Planning and Regulatory. G.Mansfield  
Reference: PB2016/00638  
Phone: 02 49742767

1 February 2016

**MODIFICATION (SSD 6580 MOD 1) TO COMMERCIAL AND RESIDENTIAL  
BUILDING - 18 HONEYSUCKLE DRIVE NEWCASTLE**

Drawing
PARKING LEVEL 2 PLAN

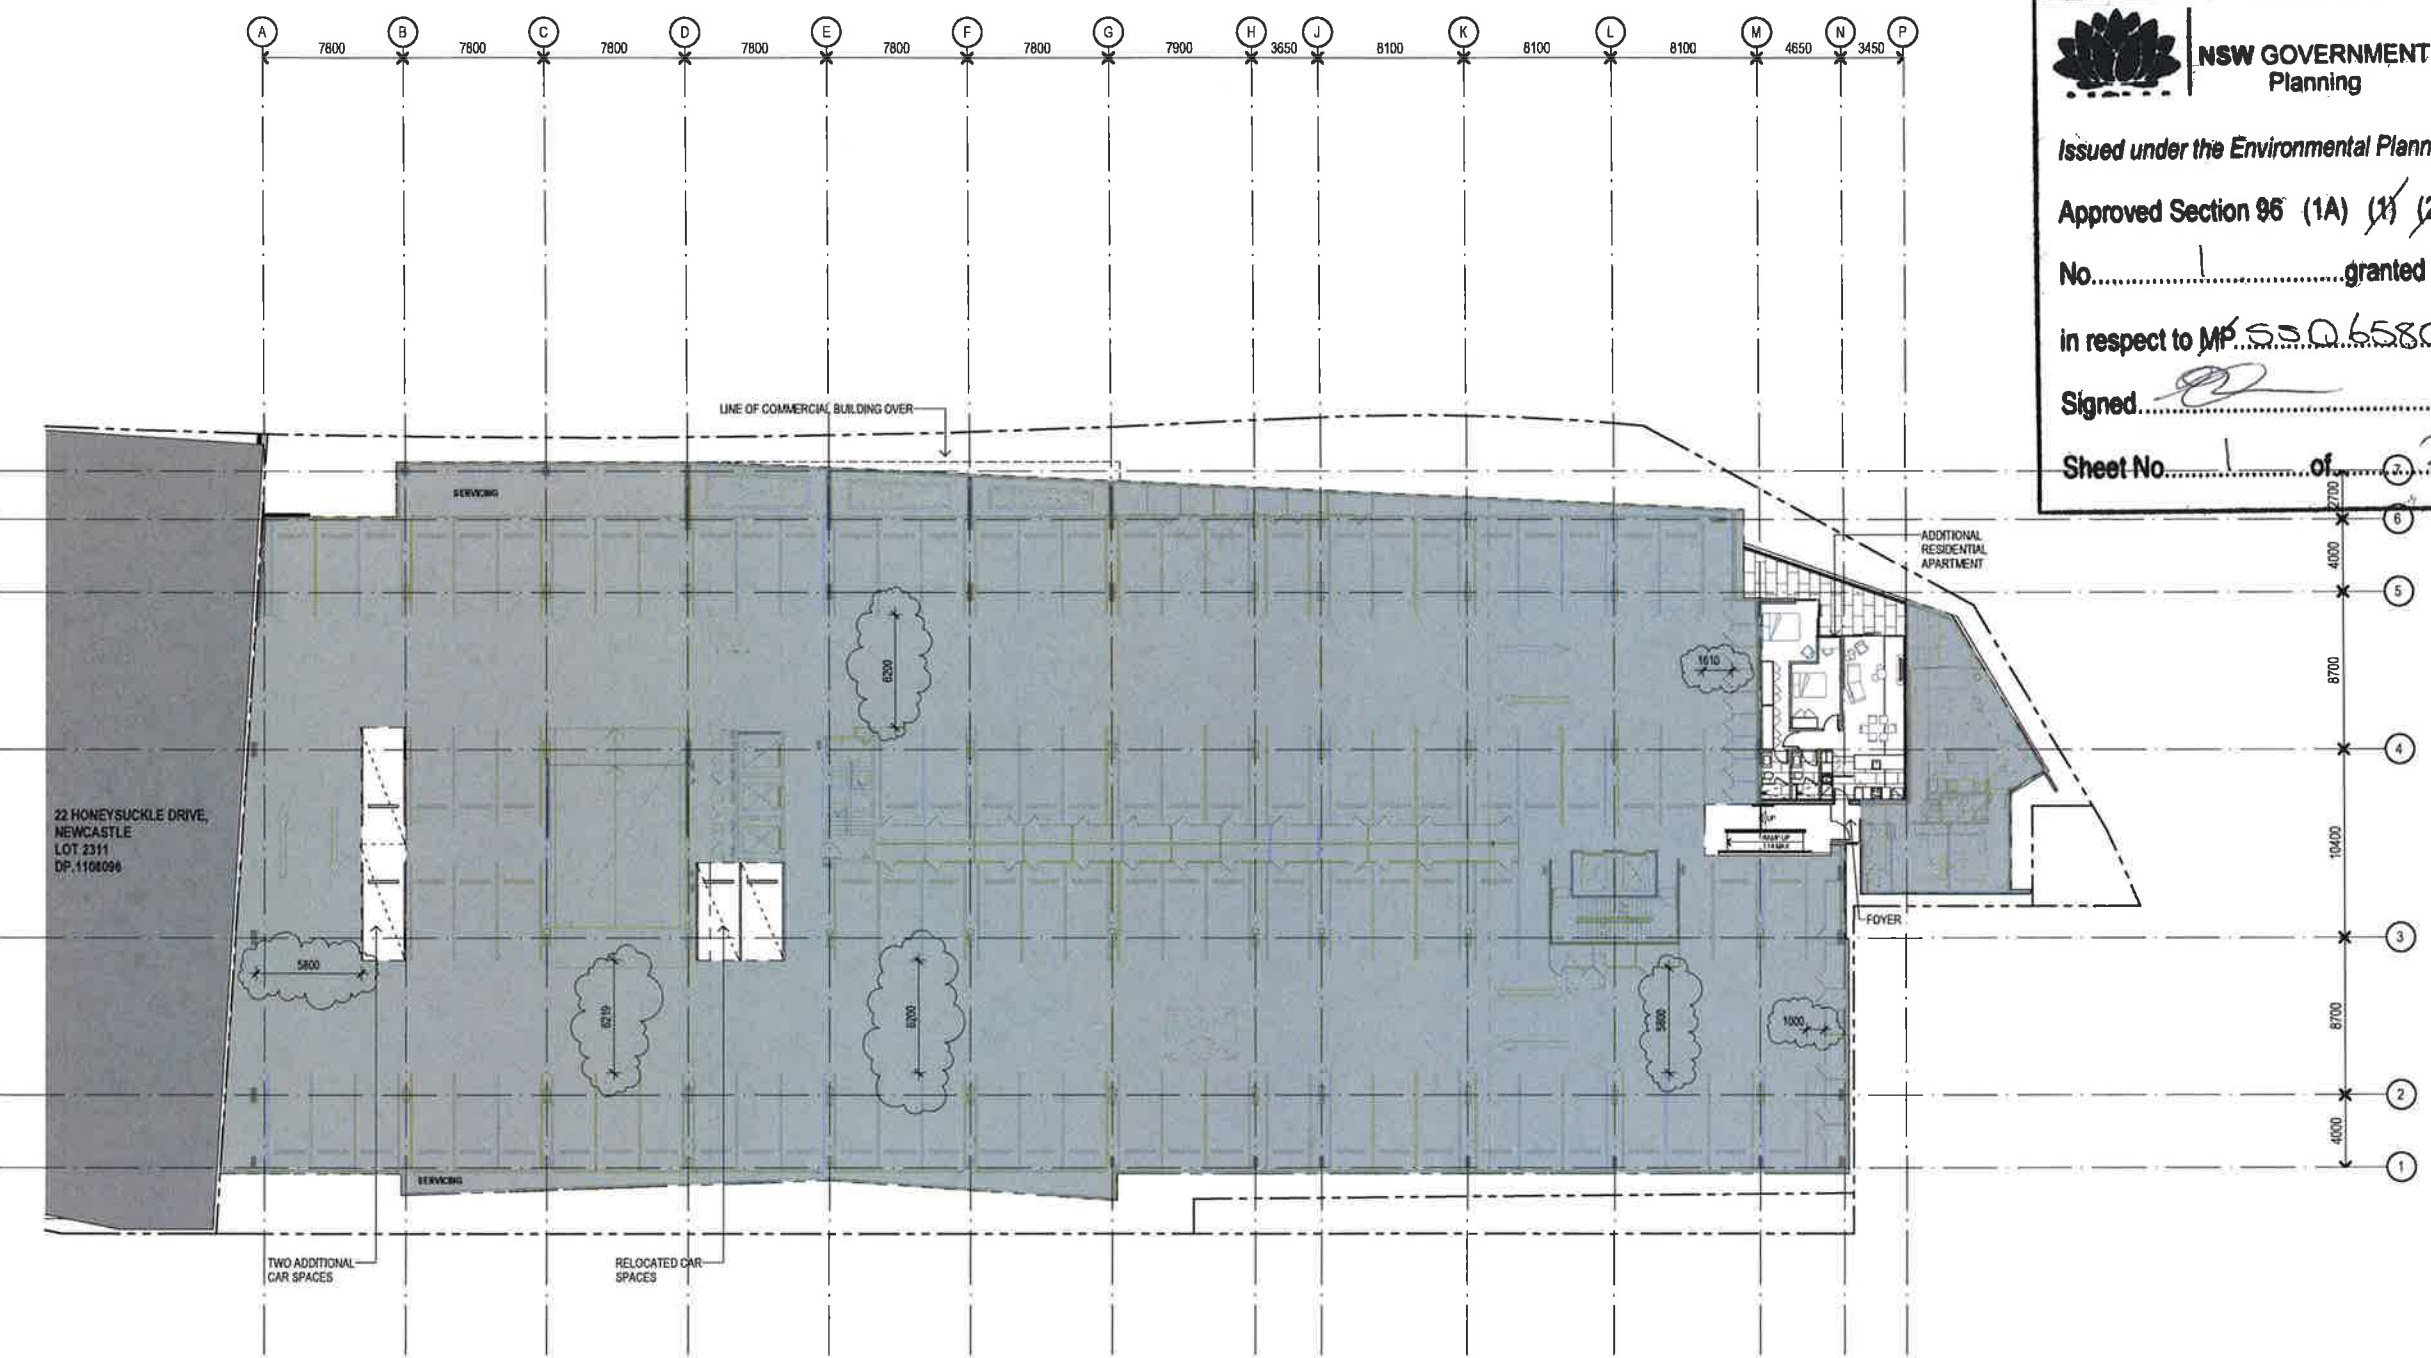
The submitted application has not demonstrated that the layout of the modified car park on level 2 of the building complies with relevant standards of Australian Standard 2890.1-'Parking Facilities' in terms of aisle widths and parking space dimensions with particular reference to user class.
